Holly Palmer - RE: TRIM: Re: MP10_0057 MOD 4 - Proposed Modification to BuildingHeights for a Residential Development at 132-138 Killeaton St, ST IVES

From: Holly Palmer [mailto:Holly.Palmer@planning.nsw.gov.au]
Sent: Thursday, 24 November 2011 5:03 PM
To: Brodee Gregory
Cc: Ben Lusher
Subject: TRIM: Re: MP10_0057 MOD 4 - Proposed Modification to Building Heights for a Residential Development at 132-138 Killeaton St, ST IVES

DRAWING TITLE:
BLOCK E ELEVATIONS

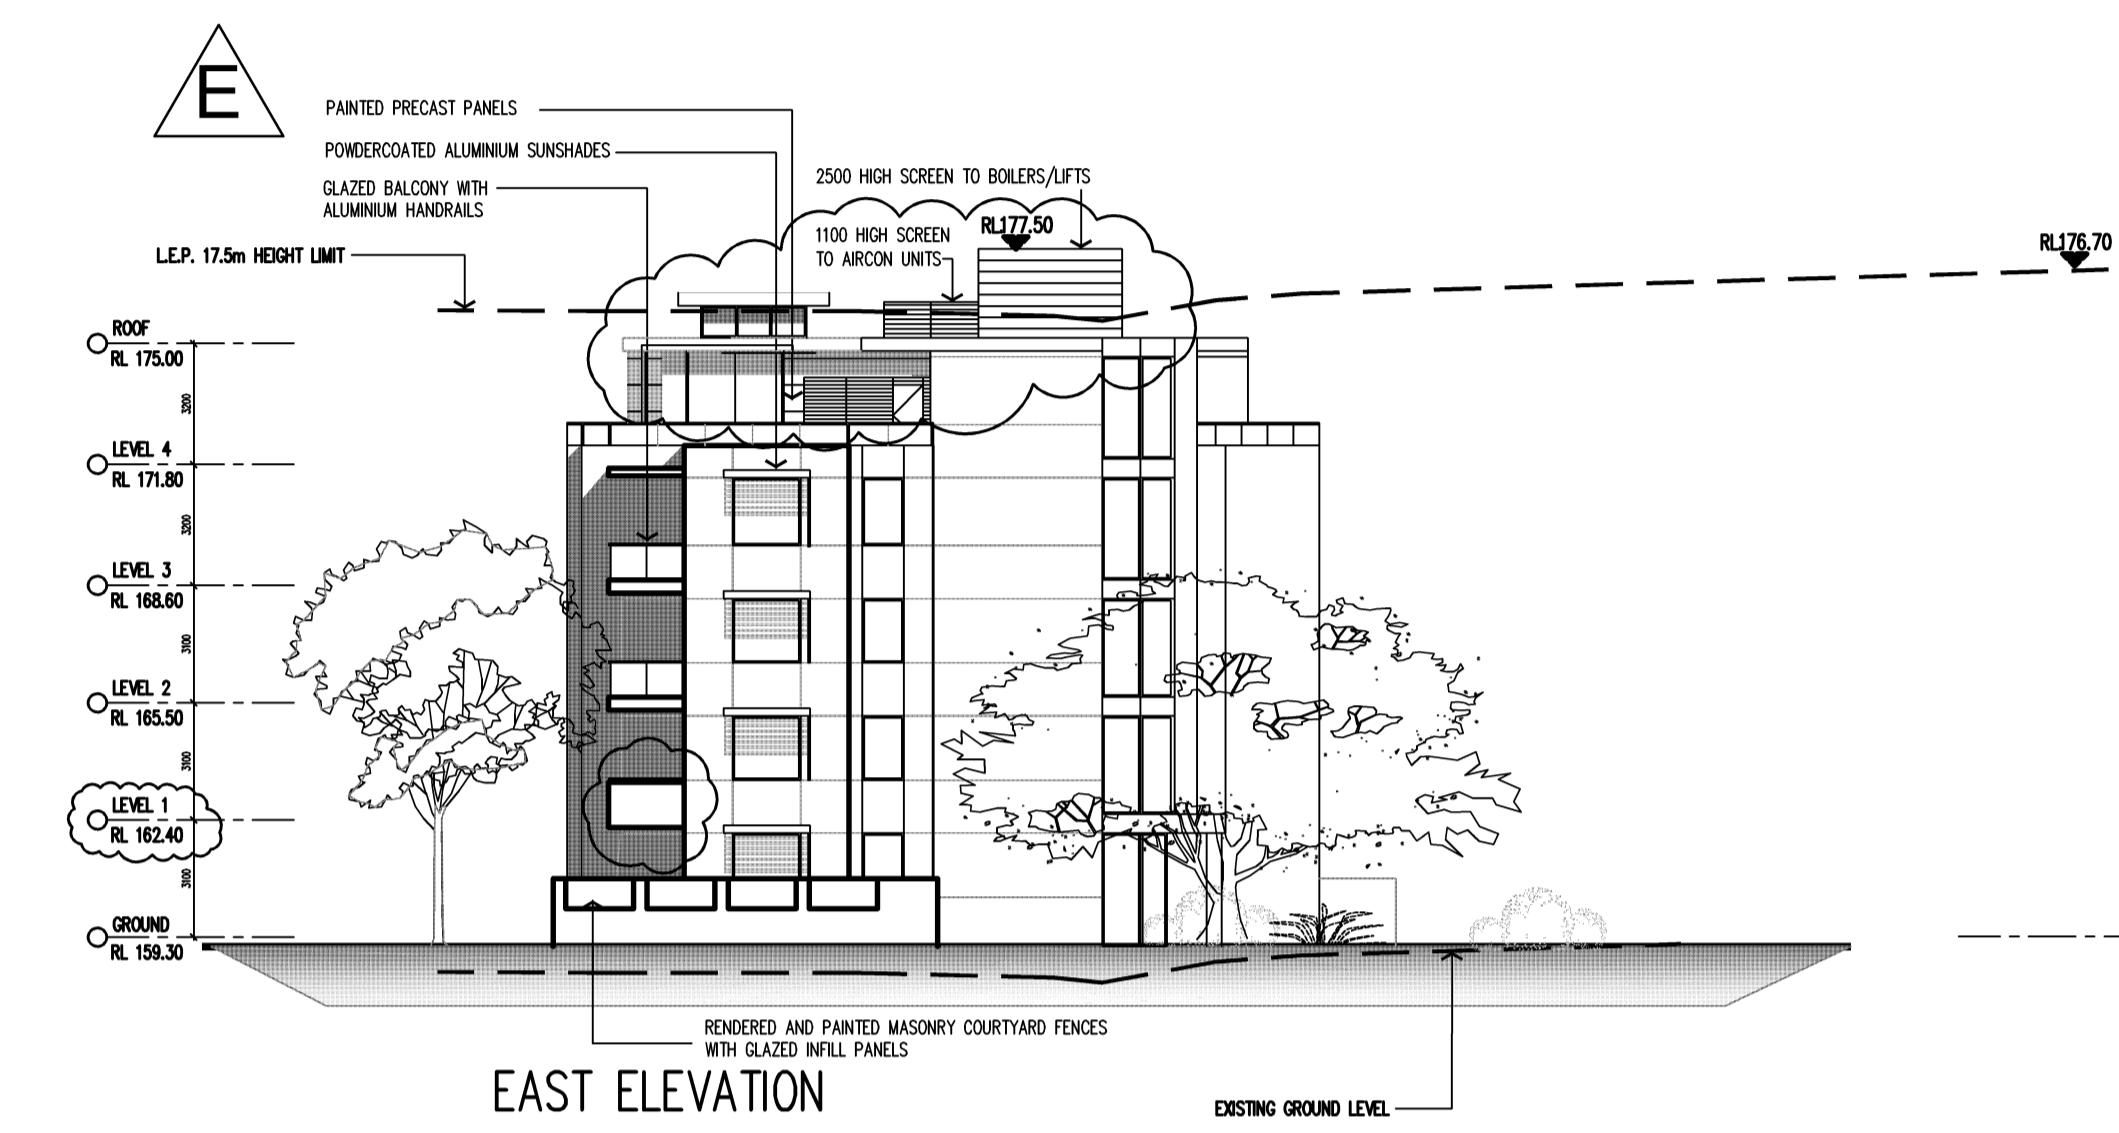
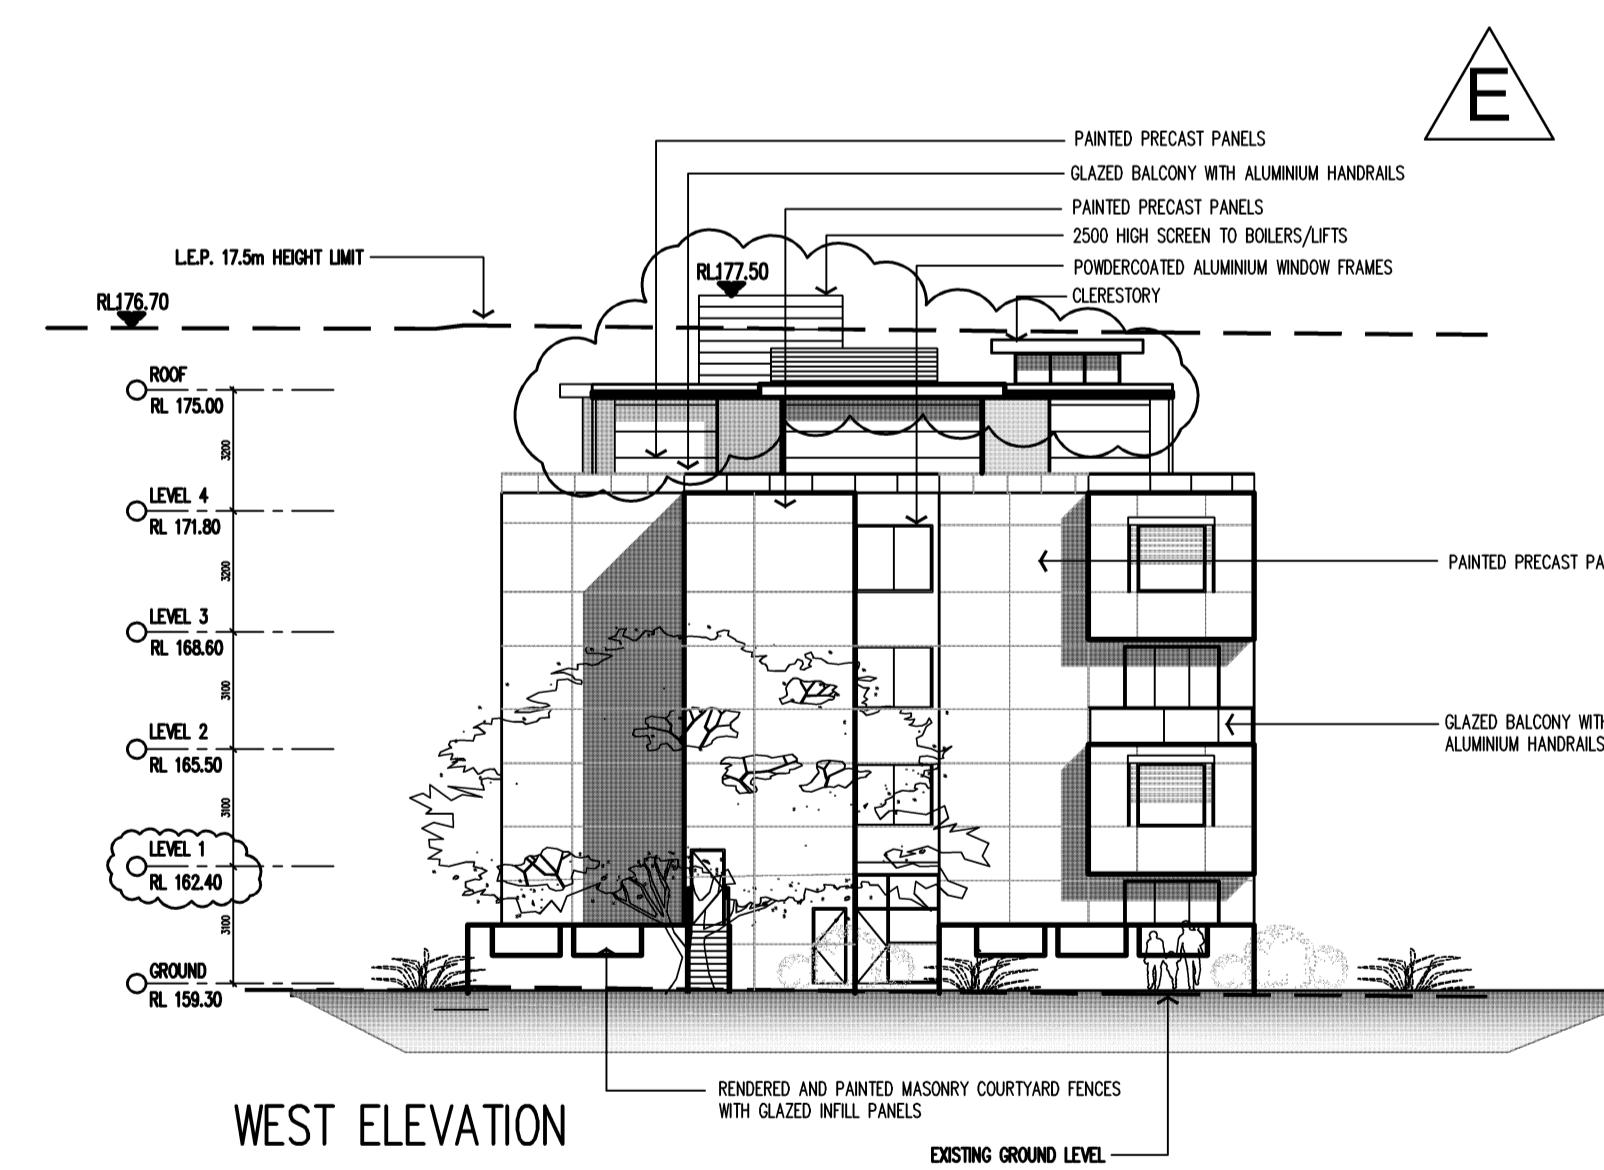
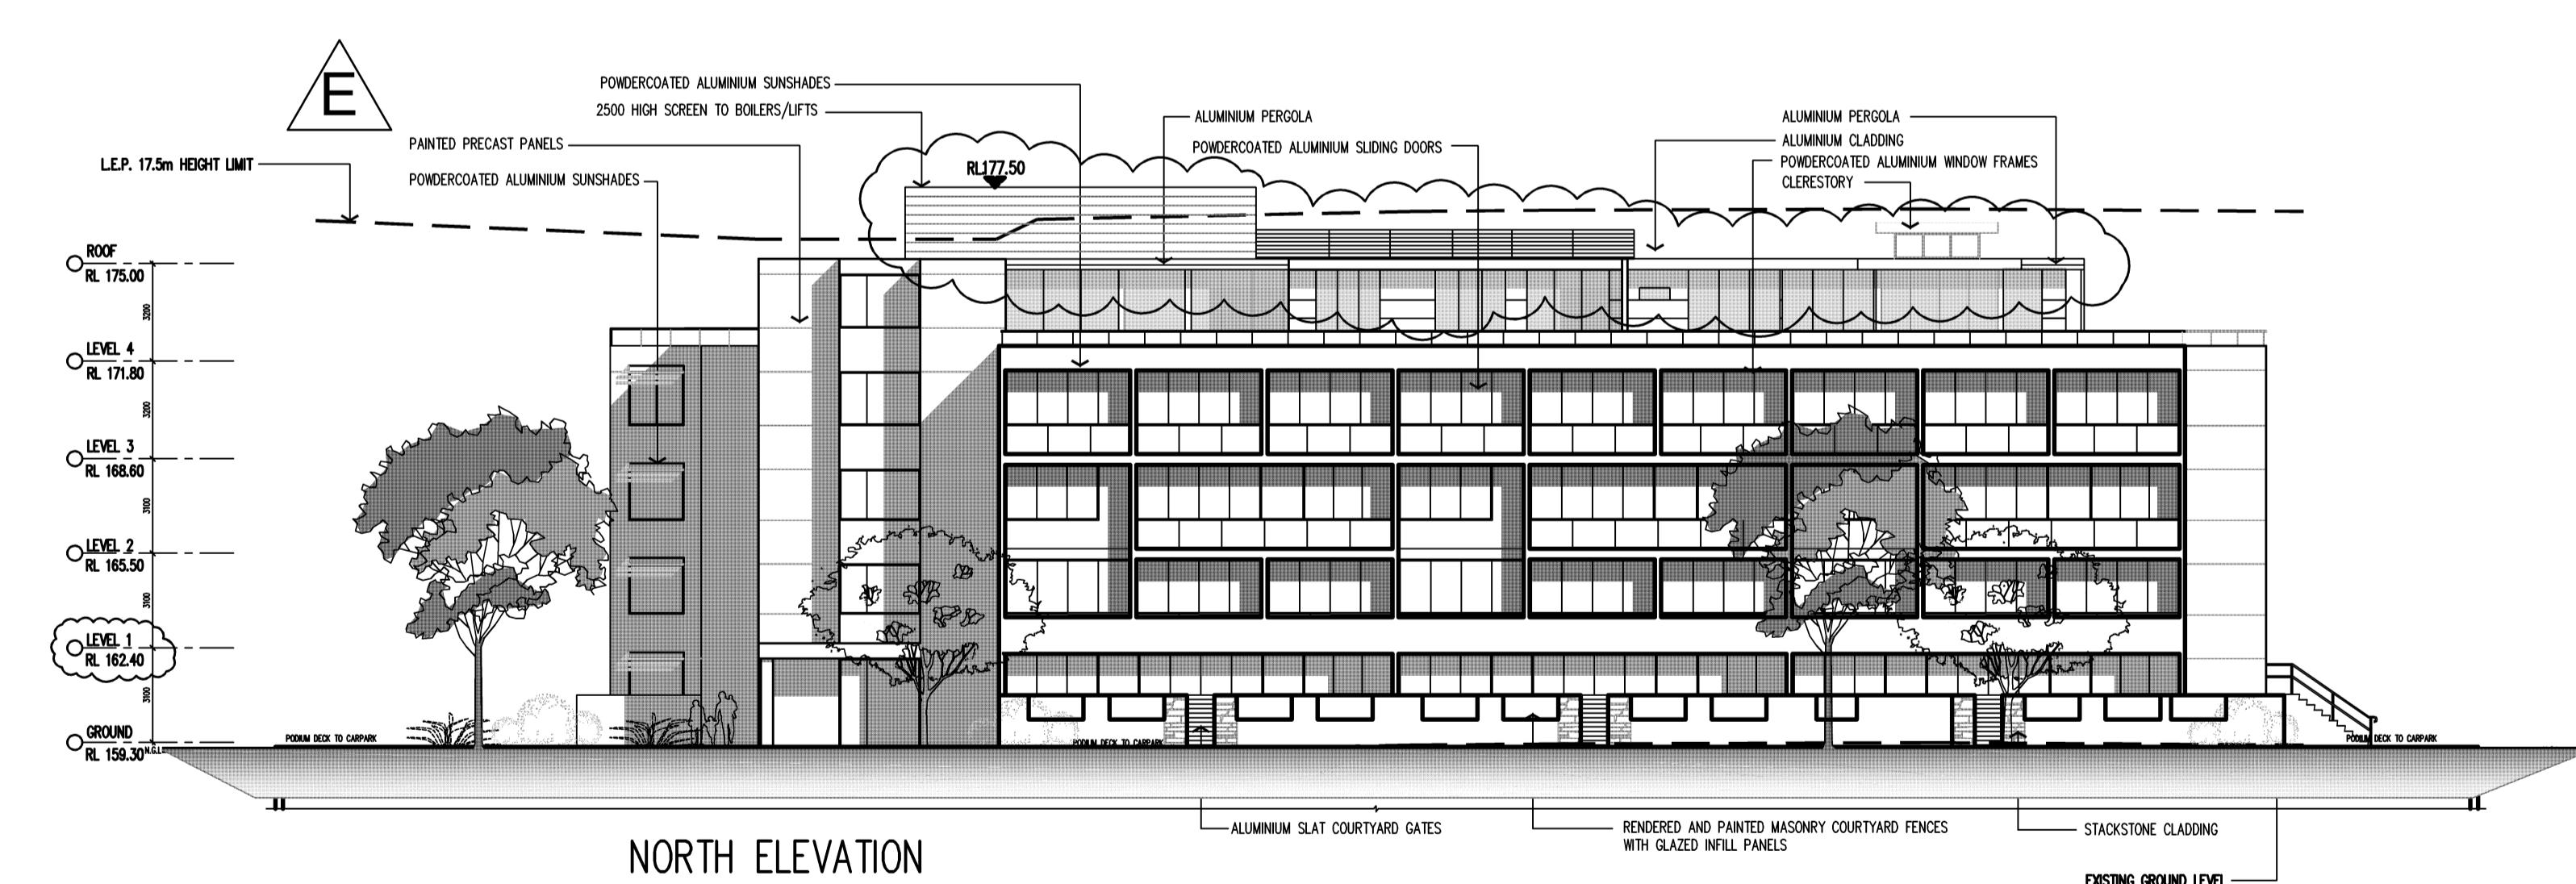
Council's original comments with regard to the proposed development still stand. The proposal significantly breaches Council's building height controls and is considered excessive.

With regard to the applicant's comments dated 22 November 2011 concerning building height, it is noted that the proposed boiler rooms are considered by Council to constitute an additional storey. The boiler rooms have a height in excess of 1.2m and are enclosed by walls and ceilings. They must therefore be classified as storeys with regard to clause 25I(9) of the KPSO
